WEST SUSSEX COUNTY COUNCIL CONSULTATION

TO:	Arun District Council FAO: Mr S Davis
FROM:	Highways, WSCC
DATE:	22/11/2018
LOCATION:	261, Aldwick Road, Aldwick, Bognor Regis, PO21 3QU
SUBJECT:	AW/279/18/RES Application for approval of reserved matters following outline approval AW/43/18/OUT for the demolition of existing dwelling & erection of two pairs of semi-detached houses & associated works.
DATE OF SITE VISIT:	n/a
RECOMMENDATION:	☒ Advice ☐ Objection ☐ Modification ☐ No Objection ☐ More Information ☐ Refusal
S106 CONTRIBUTION TOTAL:	n/a

proposed site plan

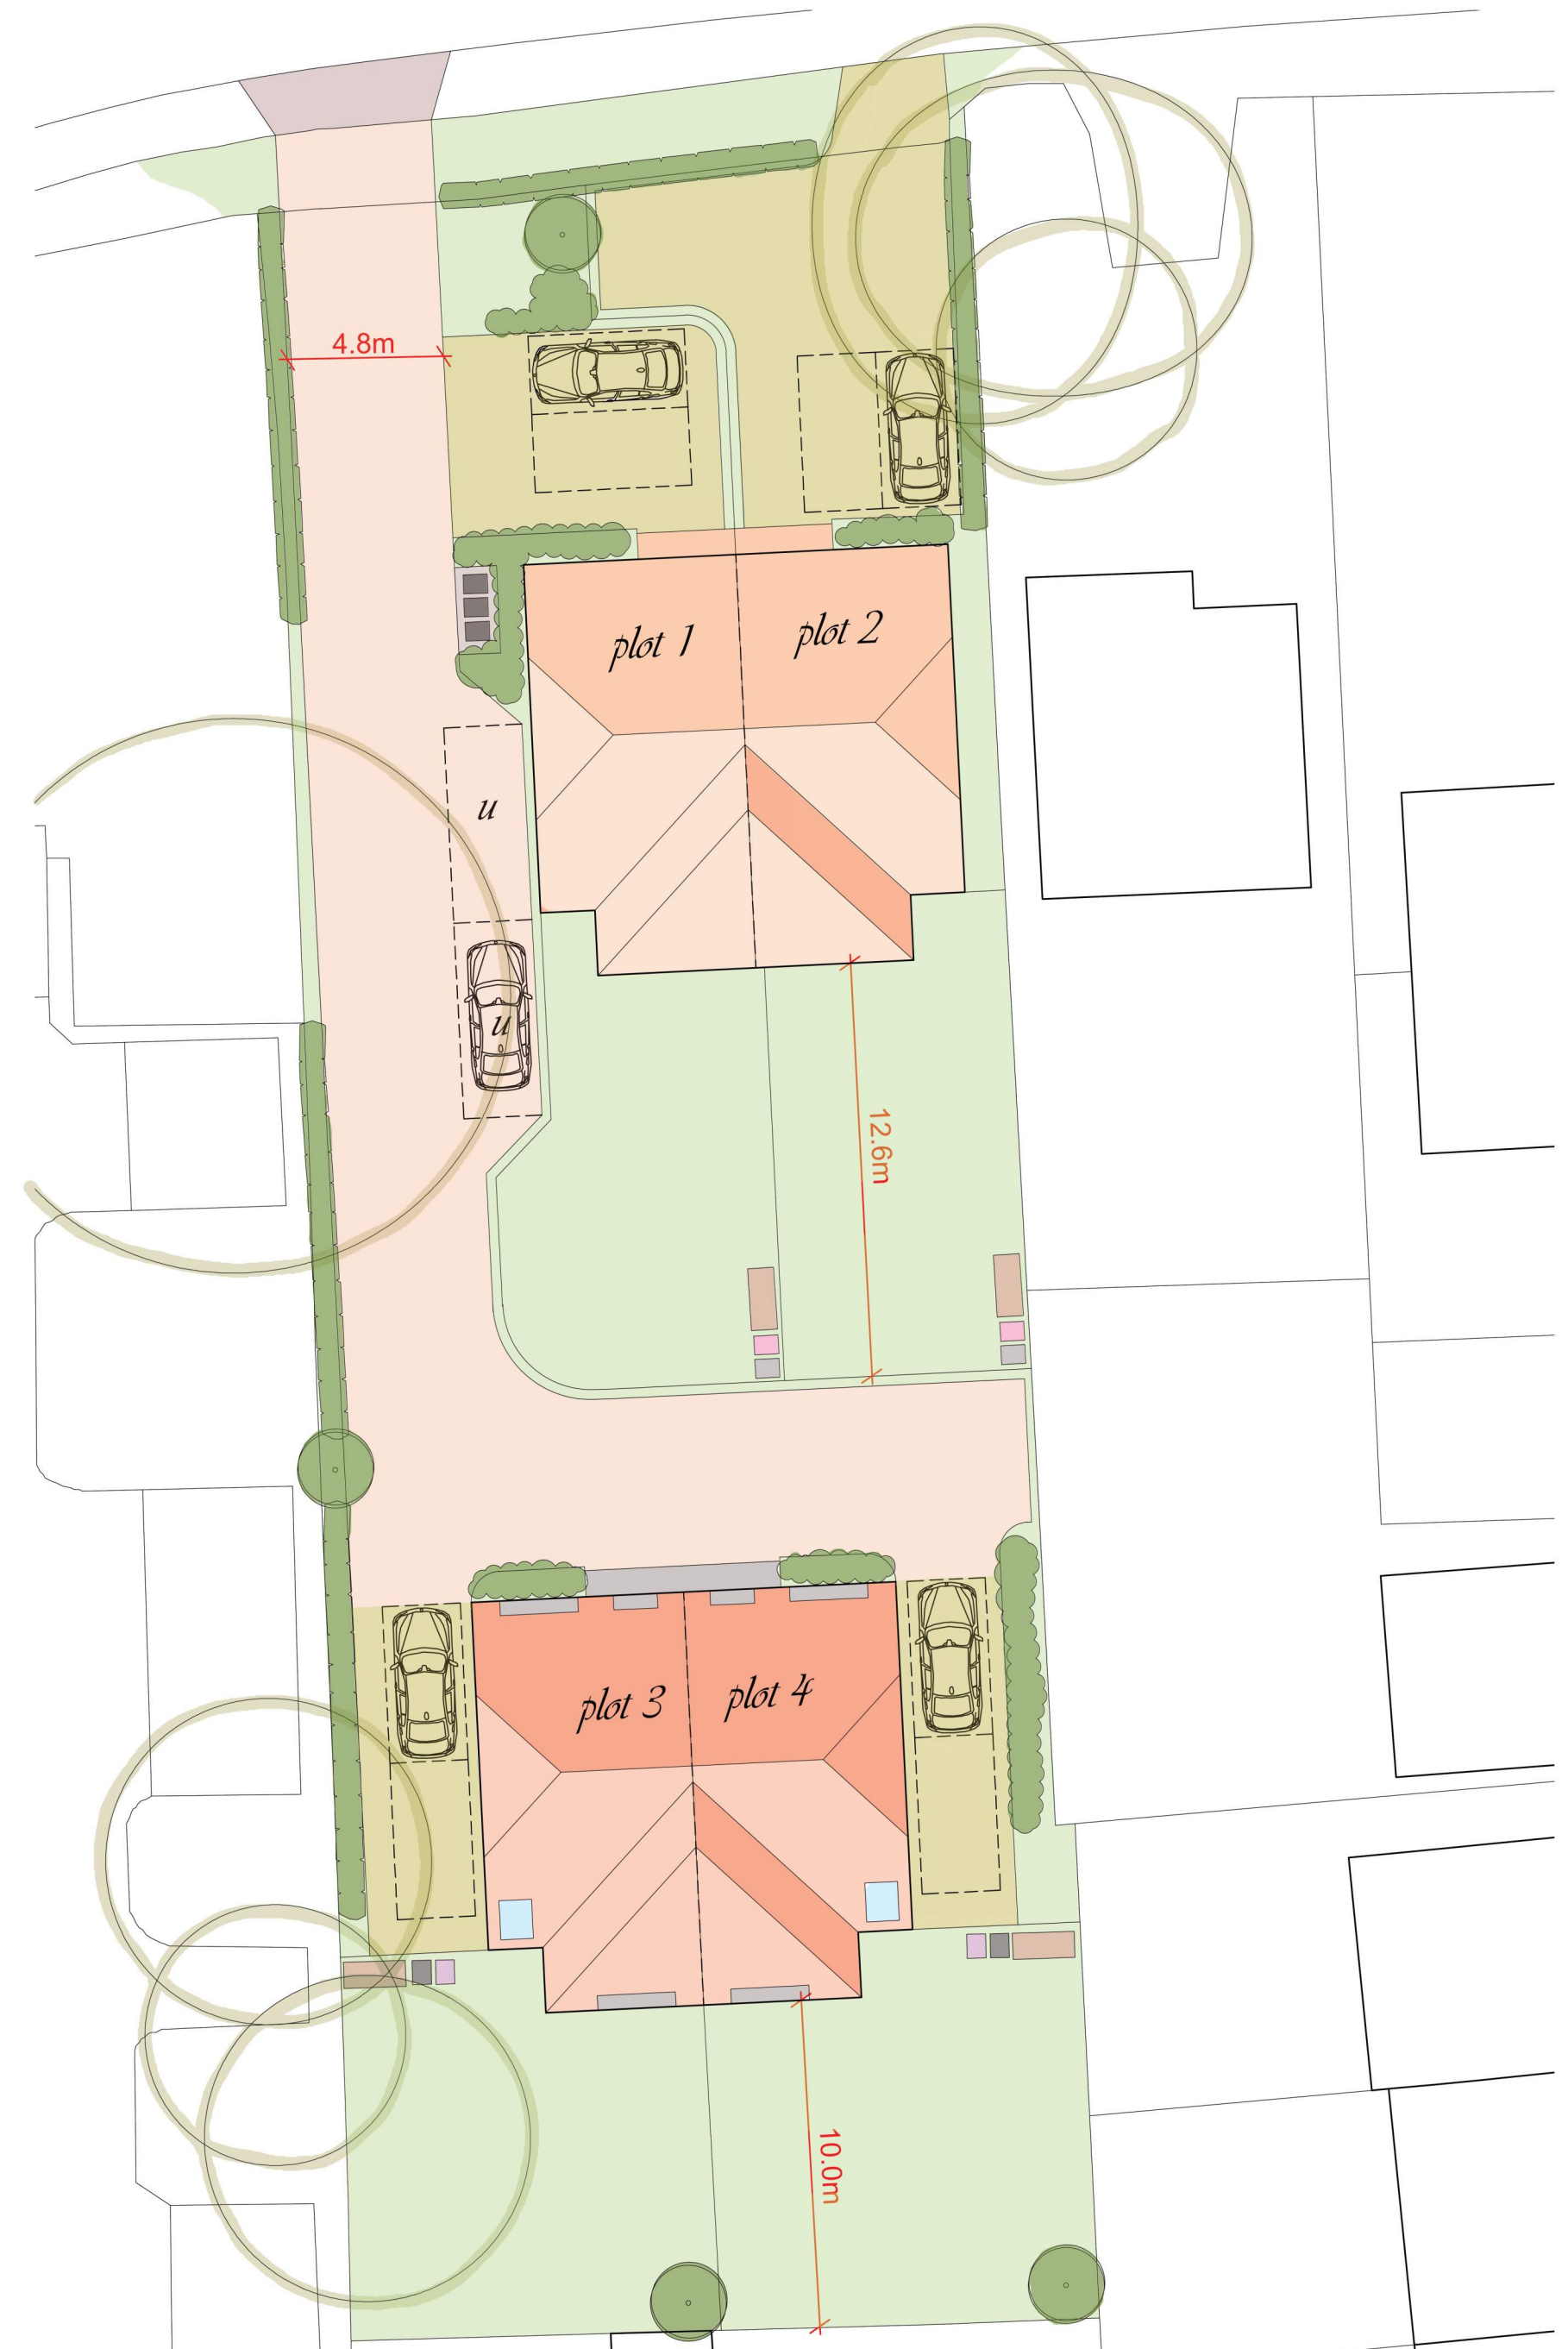
The proposed layout incorporates two hardstanding car parking spaces for each dwelling, with two additional unallocated car parking spaces for visitor/overflow parking. This quantum of car parking would be considered appropriate to meet the needs of a development of this size in this location.

The internal access ways are of a suitable geometry to allow residents to turn on site with the use of a multi-point manoeuvre.

No overriding highways concerns would be raised to the plans and details provided pertaining to the matters reserved.

No part of the development shall be first occupied until covered and secure cycle parking spaces have been provided in accordance with plans and details submitted to and approved by the Local Planning Authority.

No part of the development shall be first occupied until the vehicle parking and turning spaces have been constructed in accordance with the approved plan. These spaces shall thereafter be retained for their designated use.
